Consultation Response from KC, Highways Development Management		
2020/90450 land at, Owl Lane, John Ormsby V C Way, Shaw Cross, Dewsbury, WF12 7RQ		
Erection of restaurant with drive-thru, car parking, landscaping, play frame, customer order displays and associated works.		
Date Responded:23/03/2020	Responding Officer: Mark Berry	Responding Ref: 15-12/21

Title : **PROPOSED LEVELS**

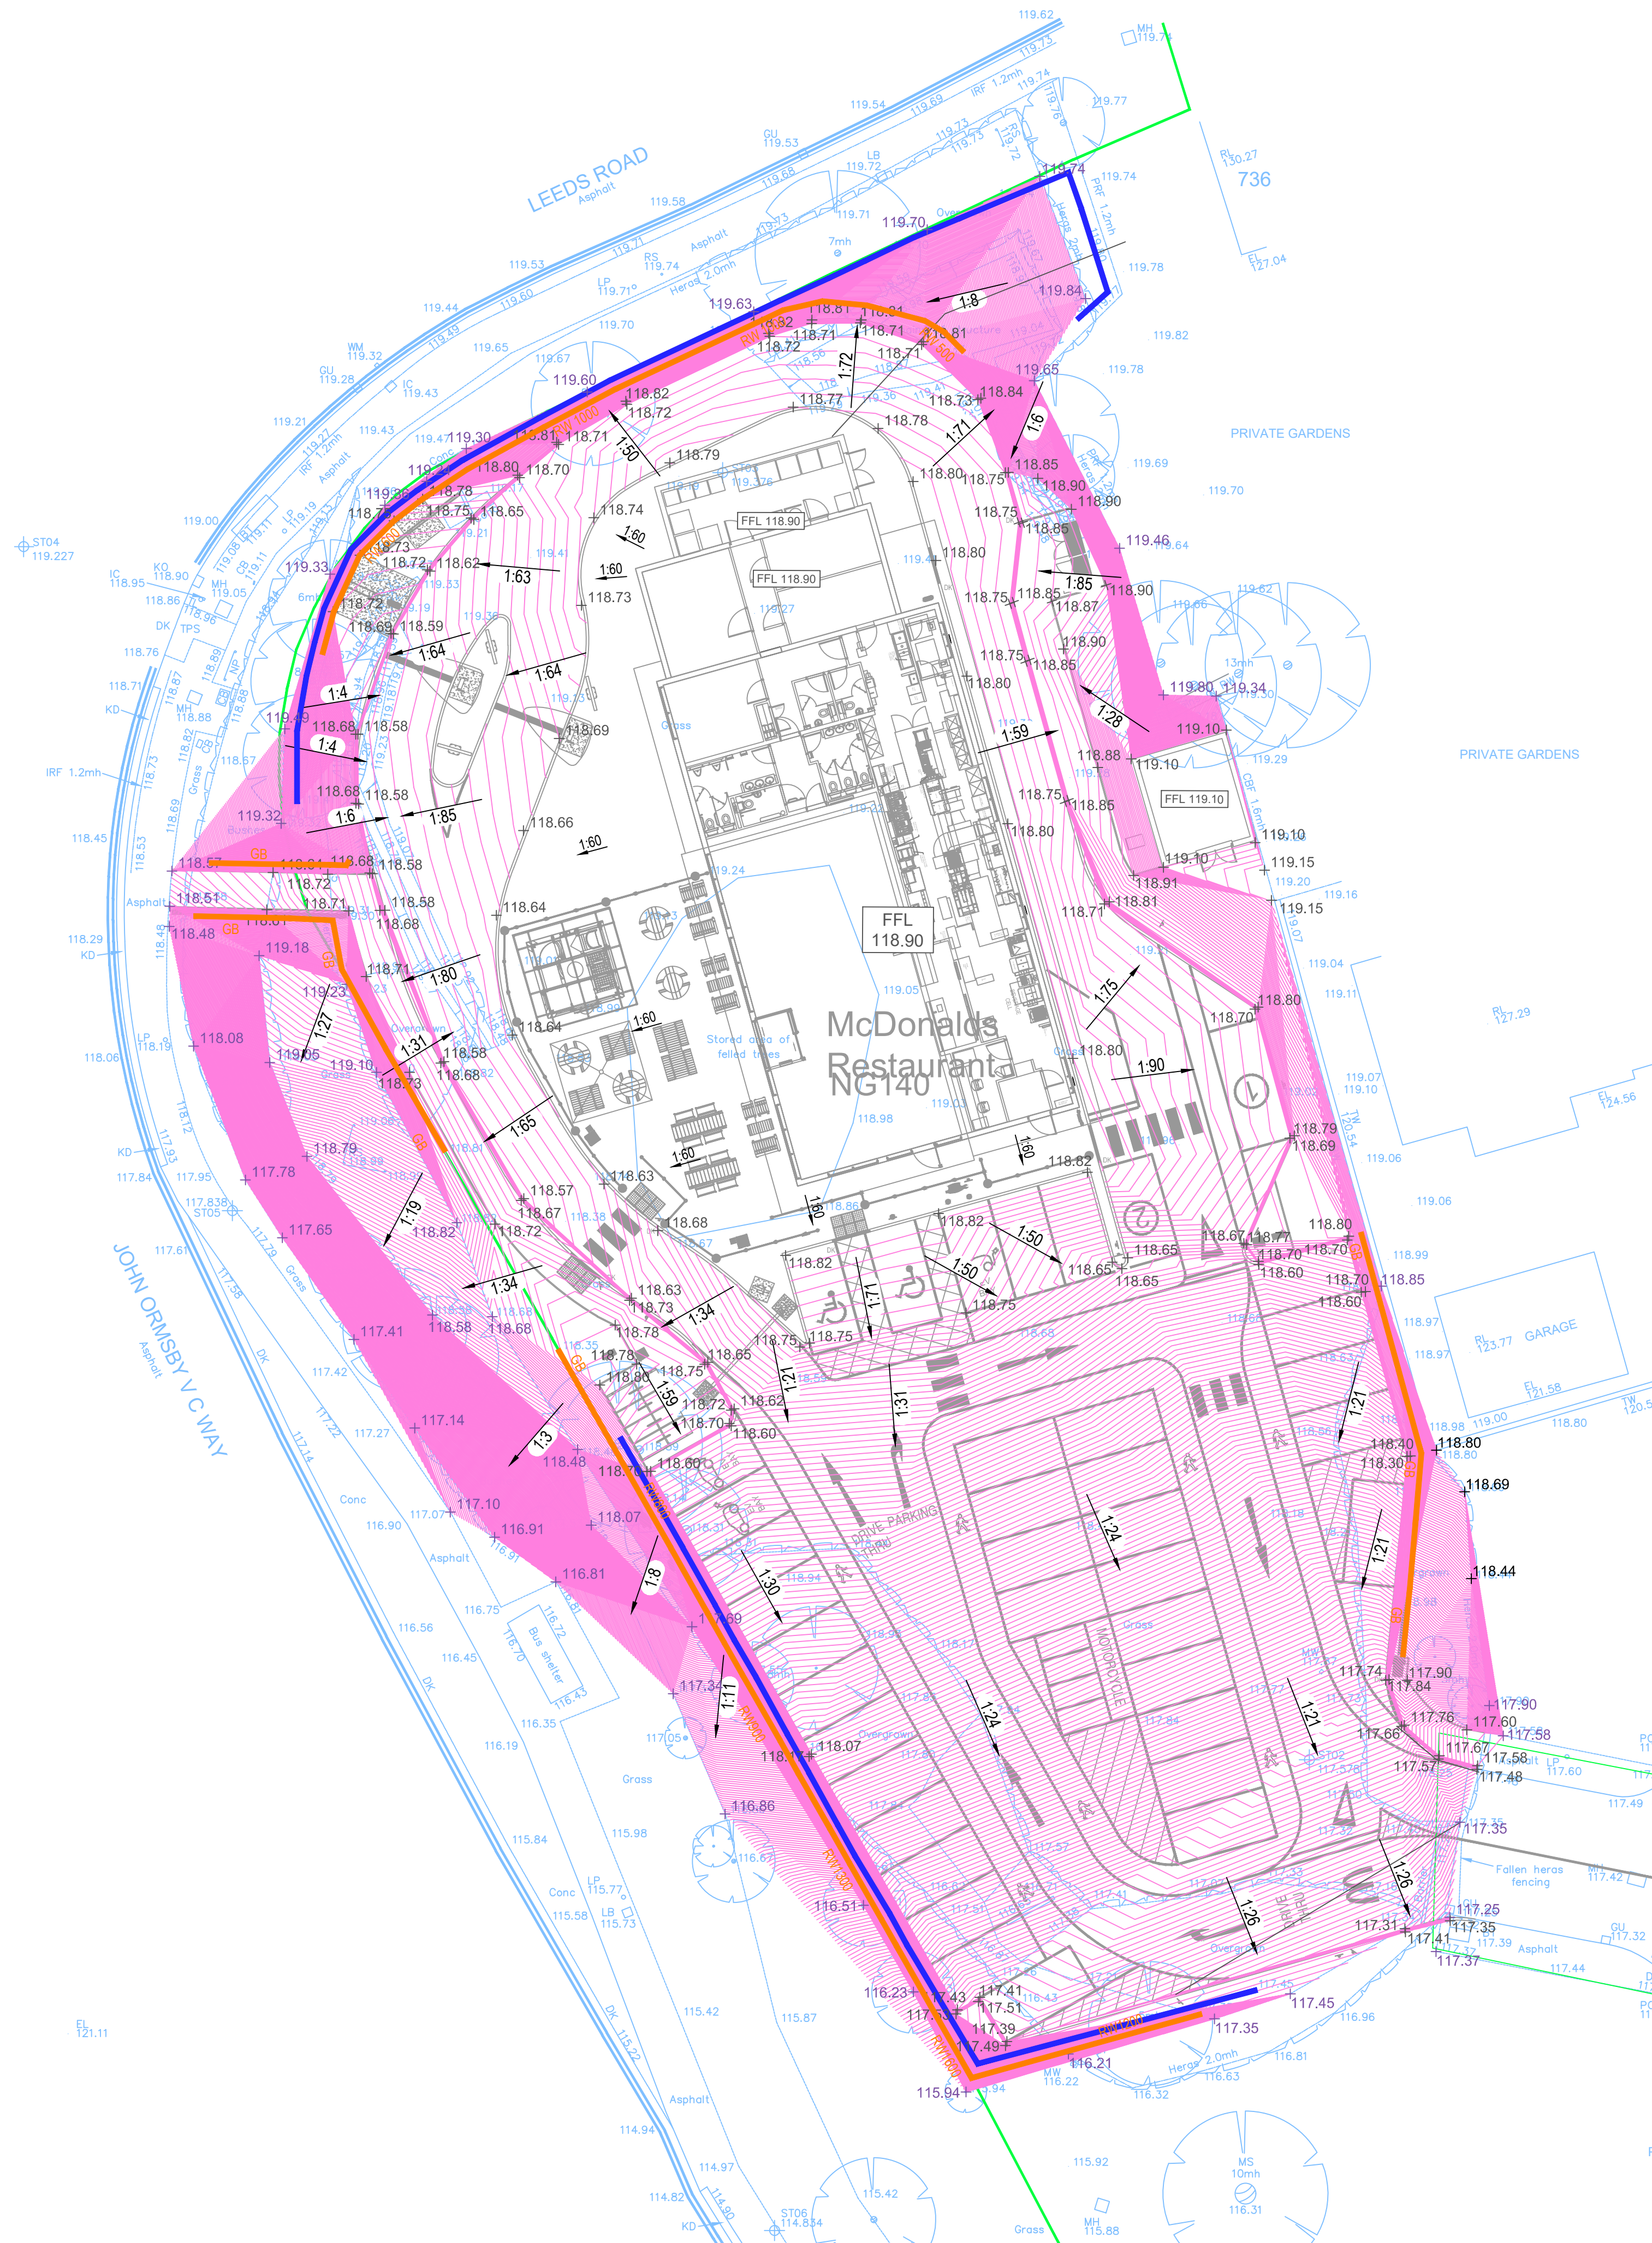
3, Gradients of the access road and parking areas should be provided.
